Subject: RE: Netherton Updates.

Thank you for providing the latest Site layout, I can confirm that my previous comments regarding junction visibility have been addressed and I have updated the **IN/01/A & IN/02/A** drawings accordingly – which are attached.

Richard Peach
Transport Planner
Optima Highways & Transportation

CLIENT HARRON HOMES			
CHECKED PMO	APPROVED PMO	DRG No. 25041/IN/01	
DRAWN BY: RP	SCALE @ A3 1:250	DATE OCTOBER 2025	REV. A

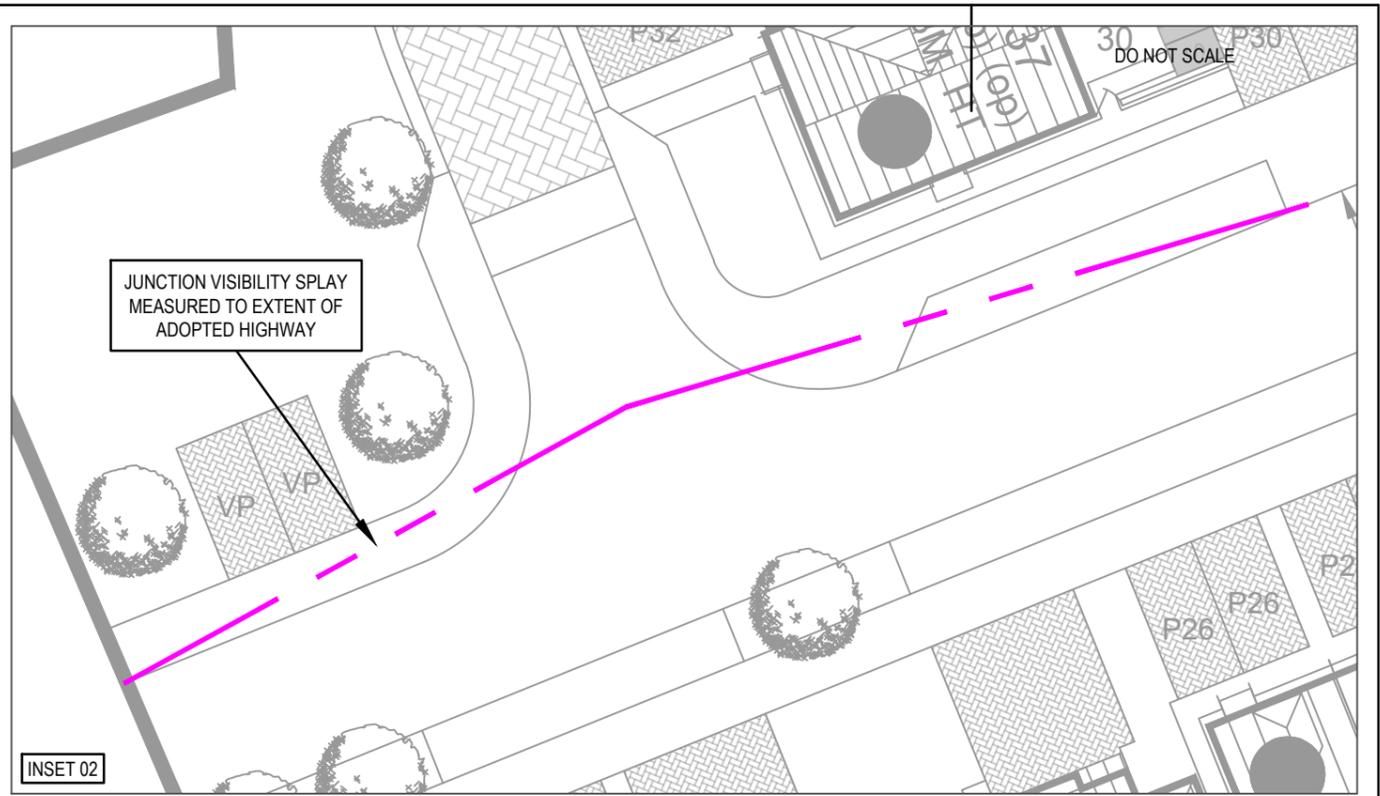
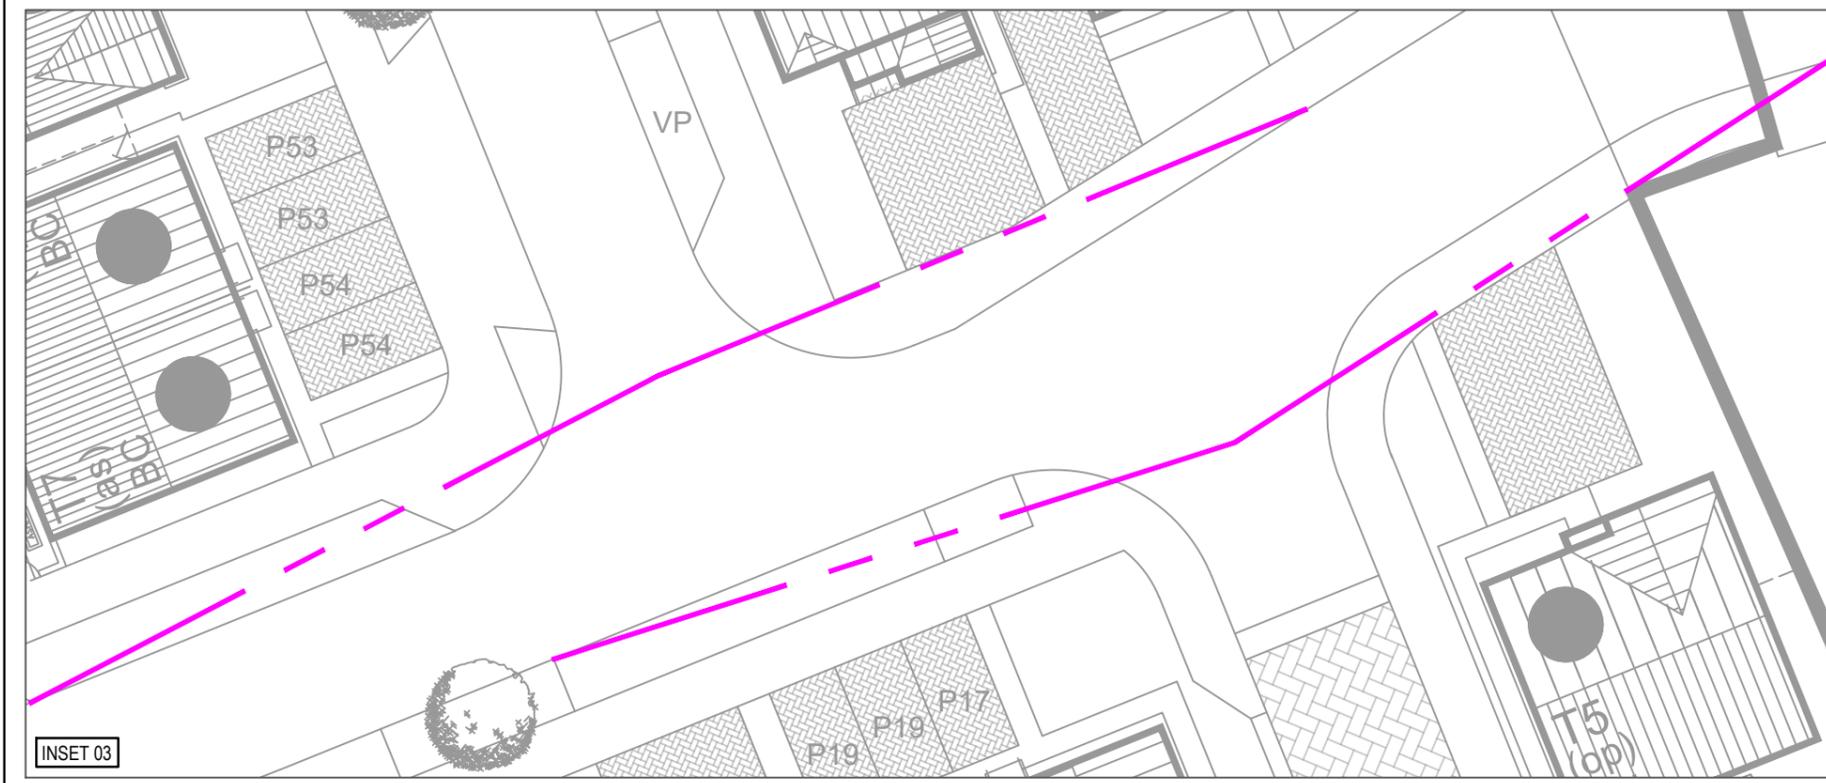
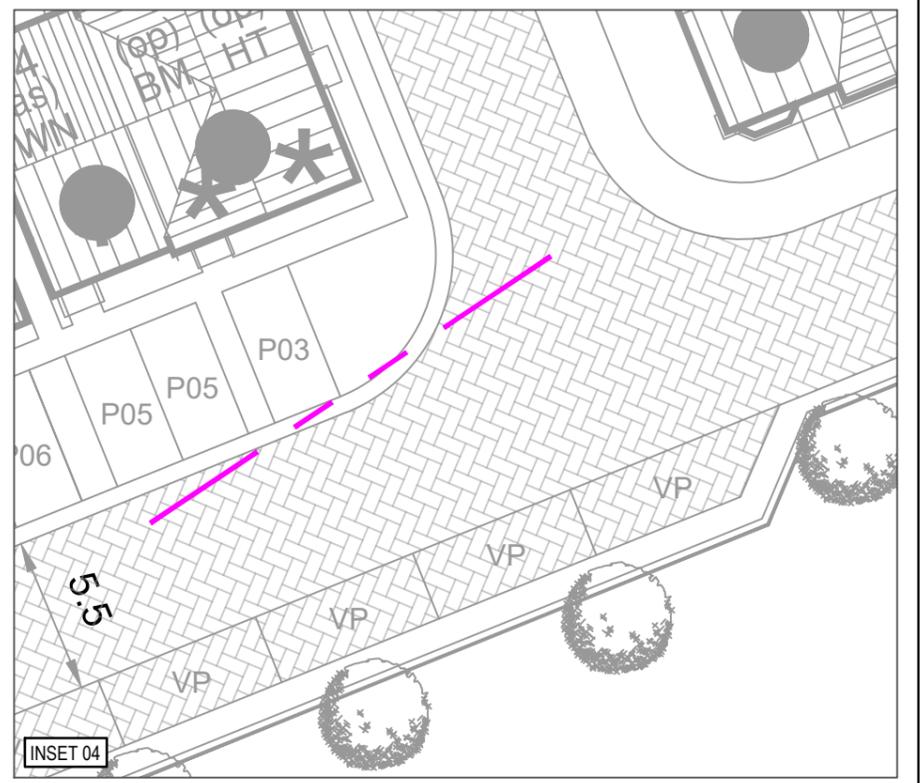
- For the junction visibility, drawing '25041/IN/01' shows the visibility splays at each junction which have been tested in respect of a 20mph design speed (2.4m x 25m) and, in most cases, can be achieved satisfactorily within the adopted highway;

- As highlighted by the Council's S38 team, the visitor parking spaces adjacent to Plots 30 & 53 are slightly impacted by junction visibility and should be located further away from the junctions;

- At the junction adjacent Plot 17, a tree falls within the visibility splay and we would recommend this is relocated;
- Junction visibility has also been tested at the junction adjacent to Plot 3. As this is a shared surface street, we have tested for a 15mph design speed (2.4m x 17m) in accordance with the Council's highway design guide and we would argue that all traffic will be turning left at this junction so will need to slow down to carry out this manoeuvre. However, even allowing for this reduced visibility splay there would be an impact on the parking space of Plot 3 if the splay is measured to the kerb line. Nonetheless, it is advised in MfS2 and is indicated by the Council that it is acceptable to measure visibility to the nearside wheel track rather than the kerb edge, meaning that the 17m visibility splay can avoid the parking space of Plot 3; and

PROJECT		CLIENT	
ROSLYN AVENUE, NETHERTON		HARRON HOMES	
DRAWING TITLE		CHECKED	APPROVED
SWEPT PATH ANALYSIS DELIVERY VEHICLE TRACKING		PMO	PMO
		DRG No.	
		25041/ATR/02	
		DATE	REV.
		DECEMBER 2025	D

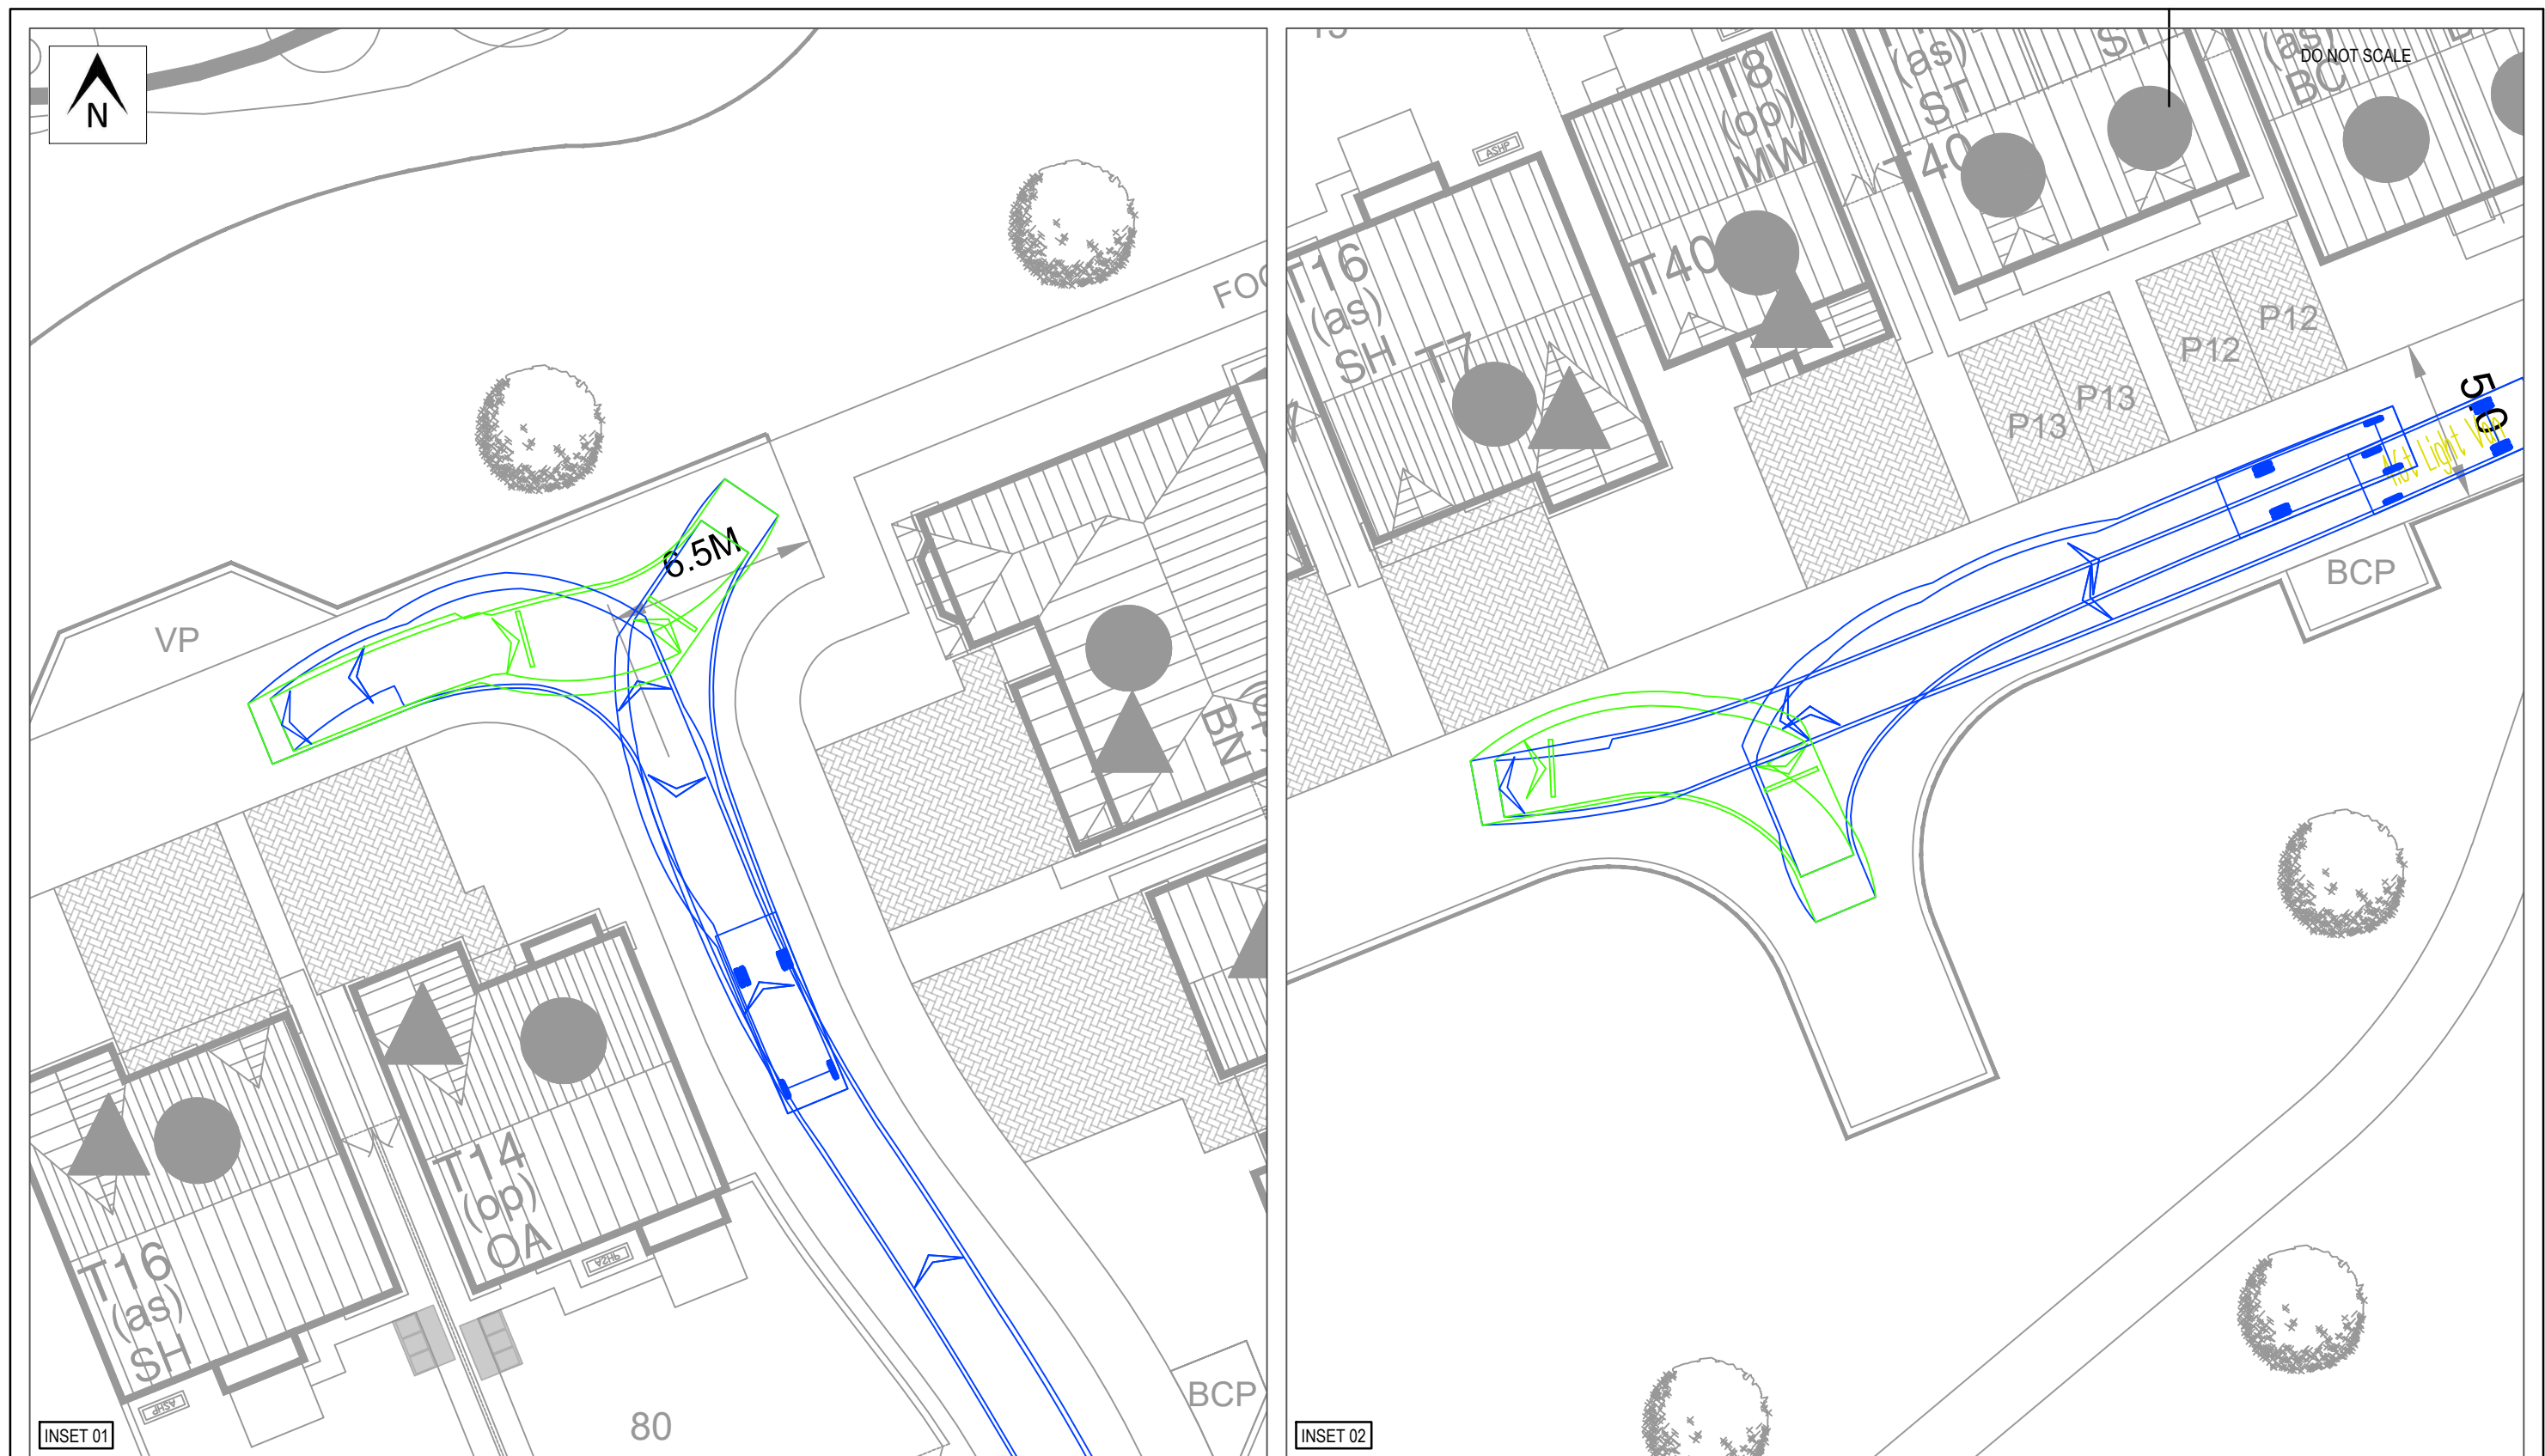
- With respect to delivery vehicle swept path analysis, this works satisfactorily and is shown in the attached '25041/ATR/02/B' drawing.

With respect to the swept path analysis, please find attached the updated **ATR/01/C & ATR/02/C** which have also been updated to display the latest Site layout. Please note that when these drawings are submitted to the Council, it may be beneficial to use the supporting information provided in my email below (dated 17th October).
